1<sup>st</sup> June 2015

**A14 Cambridge to Huntingdon Highway Improvement Scheme – Ref: TR0118**  
**Request for Site Visit -My Client : Basil King**

Drawing title: **RIGHTS OF WAY & ACCESS PLANS REGULATIONS 5(2)(k) & 5(2)(c) SHEET 10 OF 28**

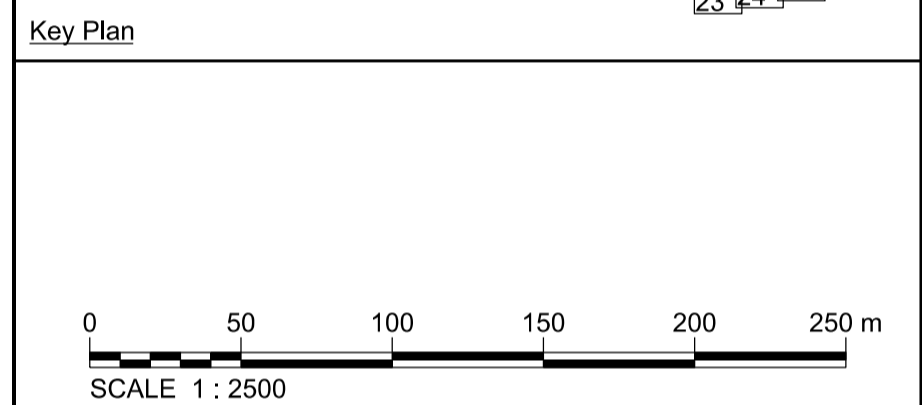
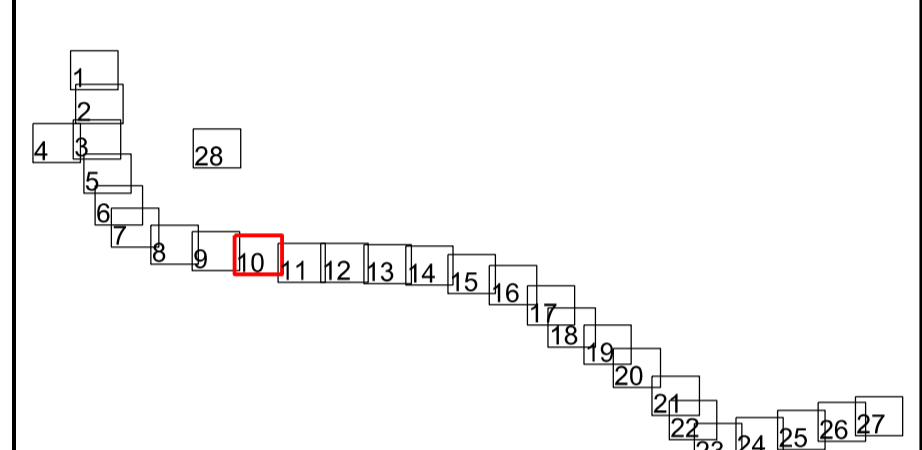
- A soil storage area has been proposed for Plots 12/2A and 11/8A. Within the field is a carp pond, currently fed by land drainage. Should this soil store be used, then the land drains would no longer be able to function due to the pressure, causing concerns about the animal welfare of the carp. This has not been addressed by Highways England.
